**KIRKLEES METROPOLITAN COUNCIL  
INVESTMENT & REGENERATION SERVICE**

**DELEGATED DECISION TO DETERMINE PLANNING APPLICATIONS**

Reference No:	<b>2023/62/92340/E</b>
Site Address:	adj, 124, Hartshead Lane, Hartshead, Liversedge, WF15 8AJ
Description:	Erection of 2 detached dwellings
Recommending Officer:	Nicole Helliwell

**DECISION - REFUSE**

PROJECT	Detached Dwelling on Plot 1 at 'Sherwood' 124 Hartshead Lane Hartshead, Liversedge WF15 8AJ		
CLIENT	Mr. D. Brown		
SUBJECT	Proposed Plans & Elevations		
SCALE	1:50 + 1:100 @ A1	DRAWN	SB
DATE	12/07/2023	DRAWING NO.	17-017-4G
		REV.	-

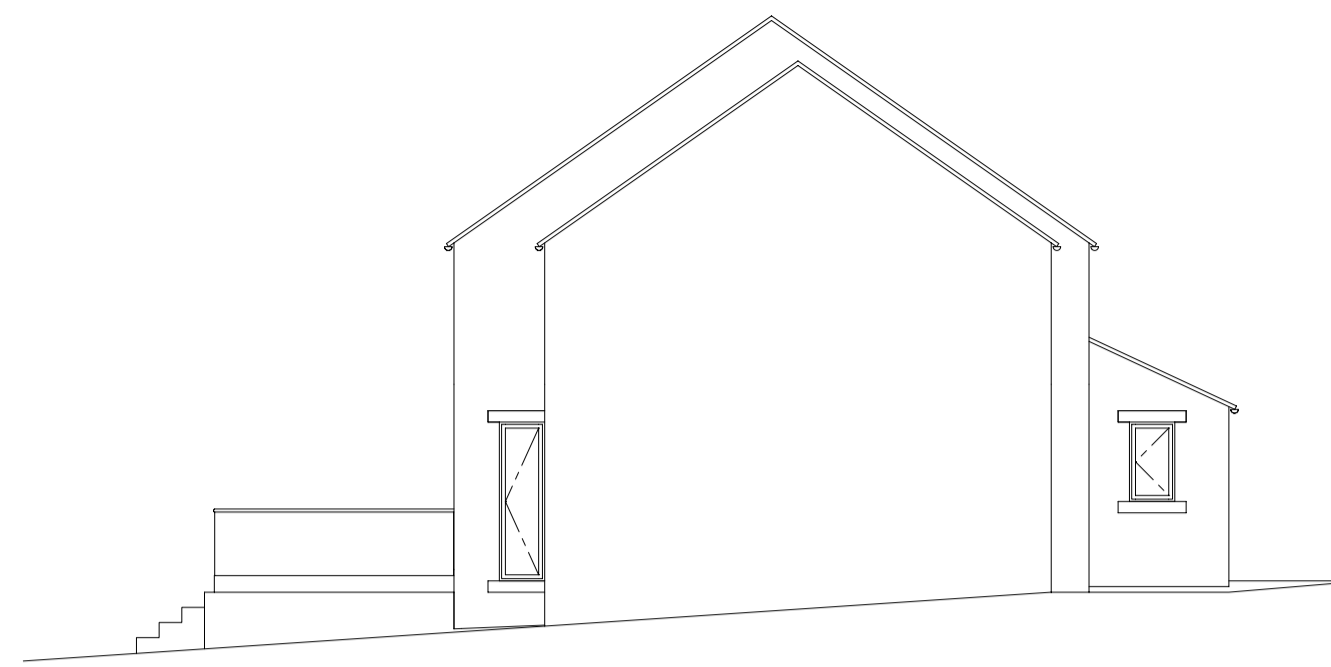
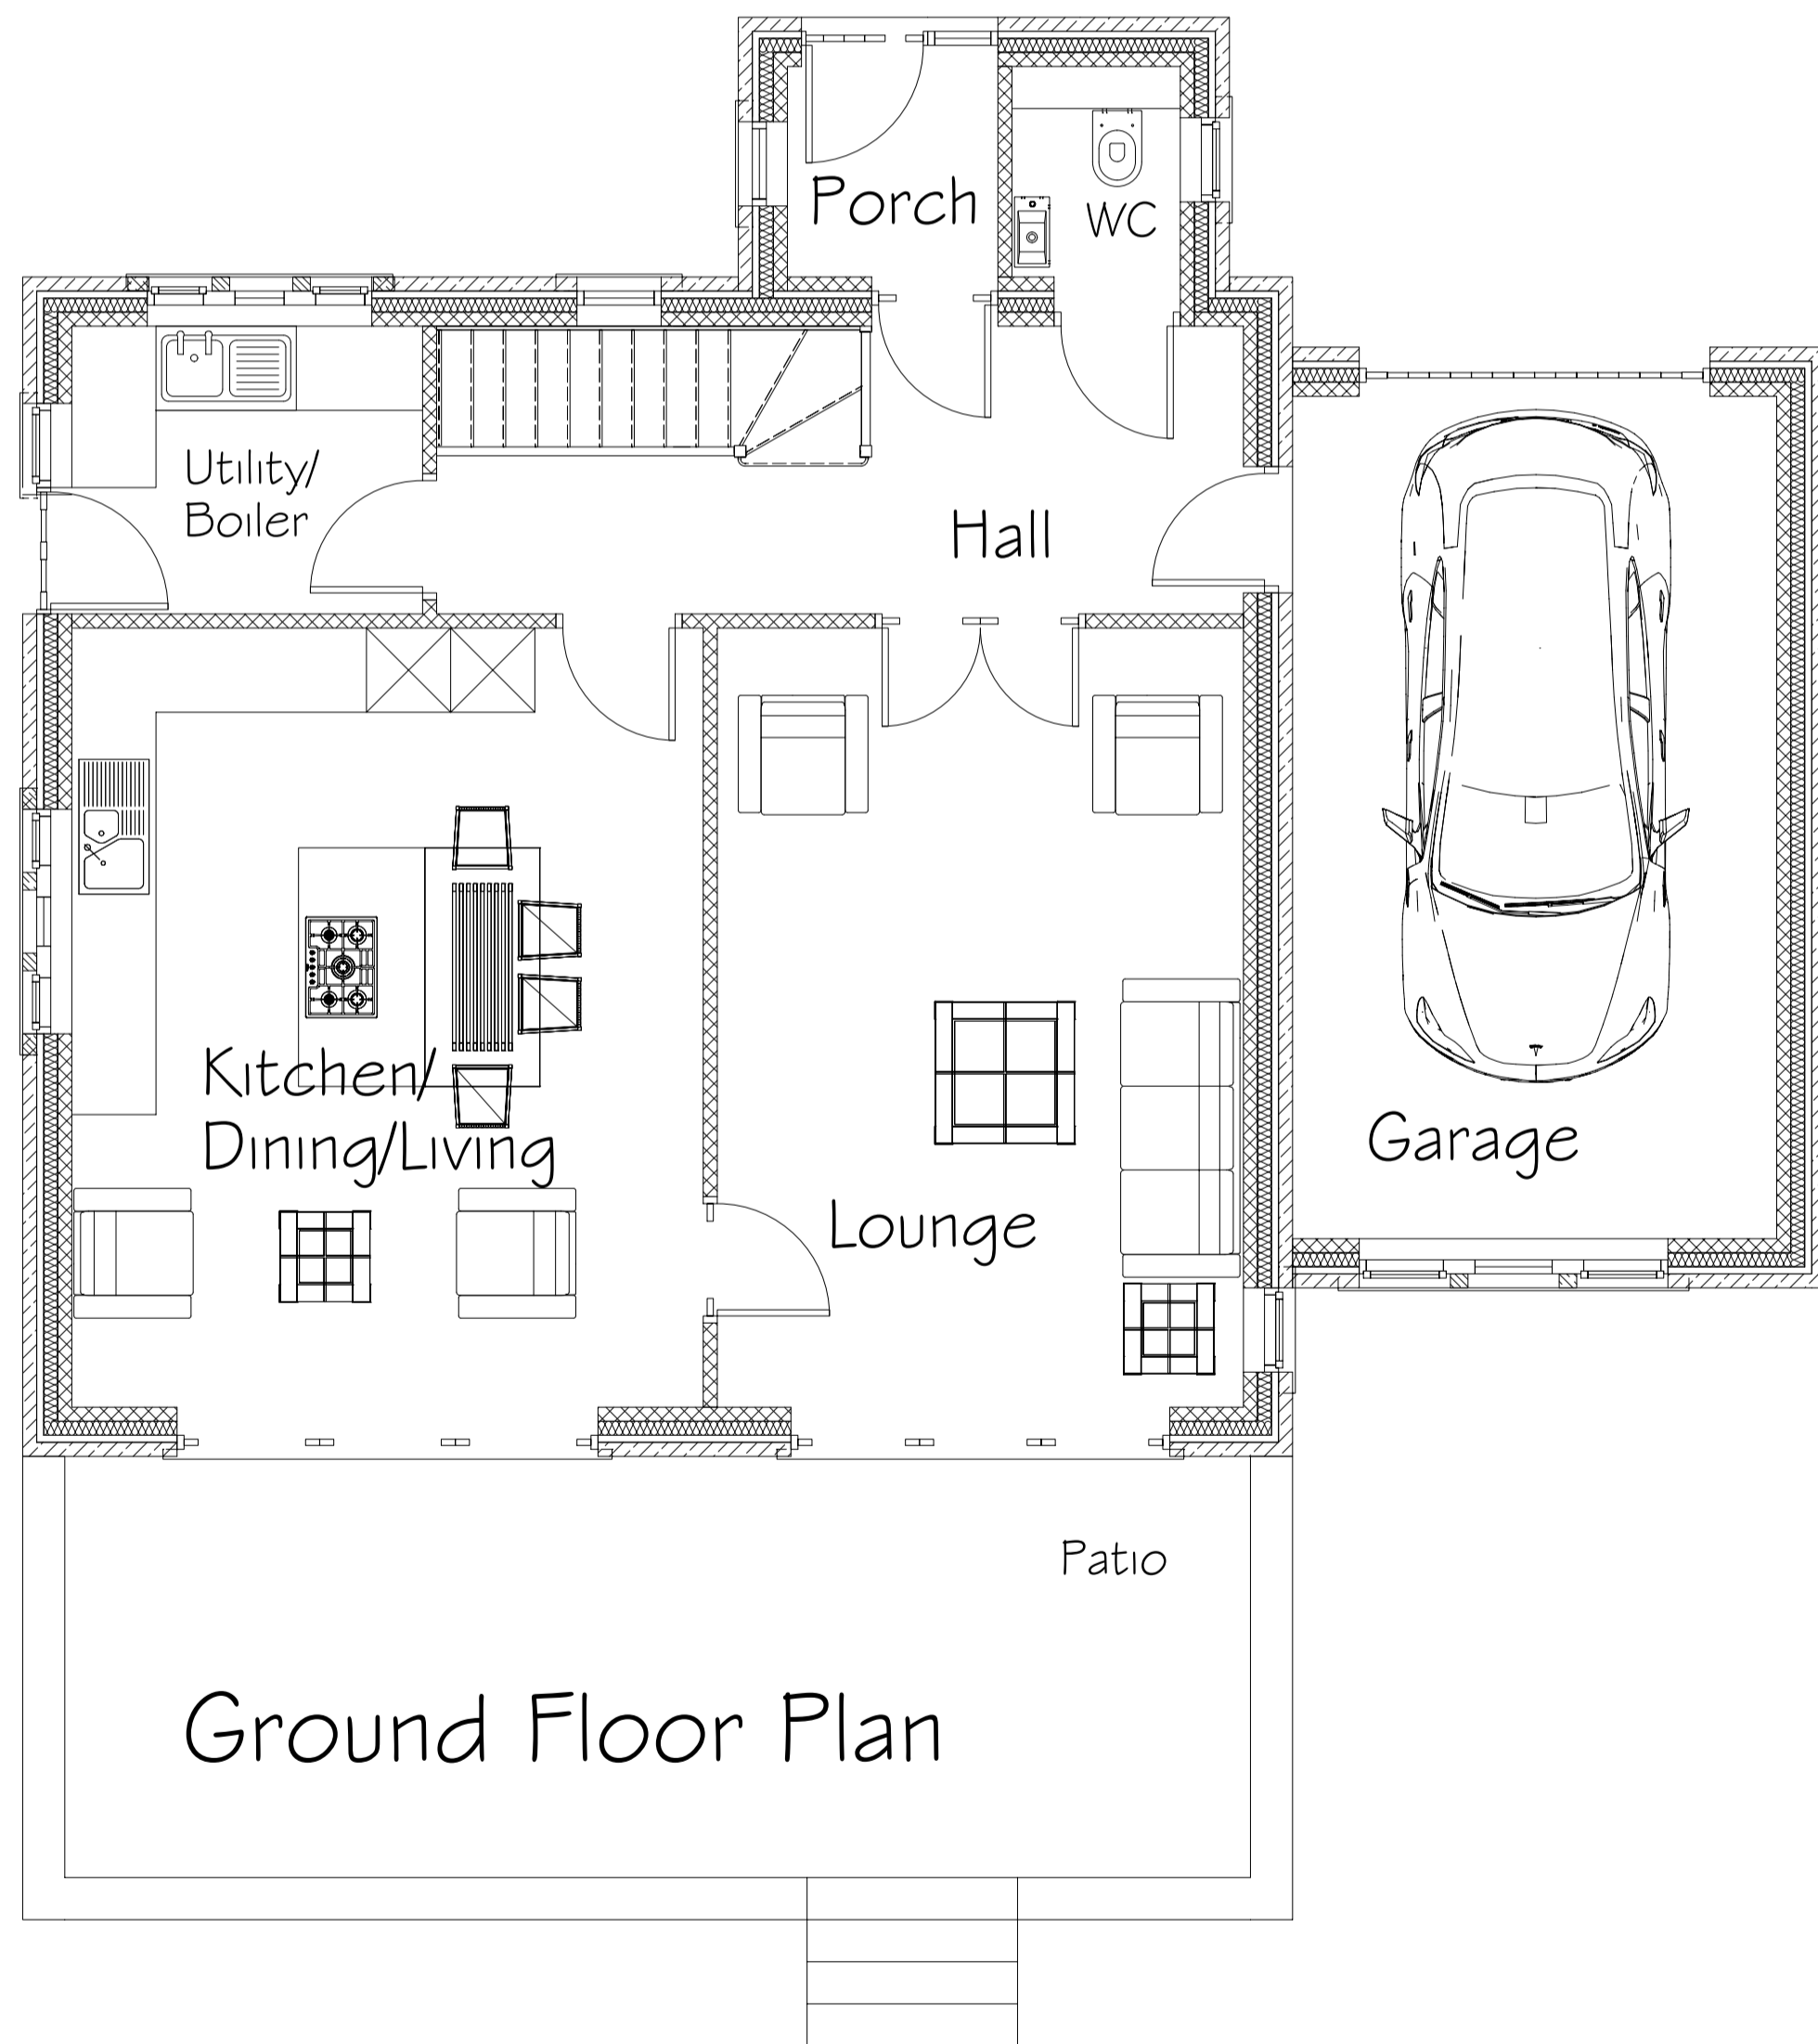
The proposed development would appear cramped which would have a detrimental impact on the setting of 120 Hartshead Lane. The proposal would threaten the sense of openness and the ability to fully appreciate

Whilst it would be possible to erect Plot 2 as previously approved (2022/92155) given that this would have a lesser impact on the setting, KC Conservation and Design would still retain an objection to the development of Plot 1. It appears that the proposal would be trying to shoehorn development which would have a cumulatively harmful impact on the setting of 120 Hartshead Lane. Whilst the degree of harm caused is judged less than substantial, it has not been demonstrated that this would be outweighed by a public benefit

The proposed floor plans show that both dwellings would have three bed spaces and therefore are required to have an internal floor space of 84m<sup>2</sup>. Plot 1 would have an internal floor space of 179m<sup>2</sup> and Plot 2 would have an internal floor space of 240.6m<sup>2</sup> which would exceed the guidance for a two storey dwelling. It is also noted that each of the habitable rooms would benefit from a sufficient amount of natural light. Furthermore, areas of private outdoor amenity space are proposed to the rear and off road parking would be located to the front of the dwellings. For these reasons, it is considered that the proposal would adequately meet basic lifestyle needs and provide a high standard of amenity for future occupiers in accordance with LP24(b) of the Kirklees Local Plan, Principles 6 and 16 of the Council's Housebuilders Design Guide SPD, and Paragraph 130 (f) of the National Planning Policy Framework.
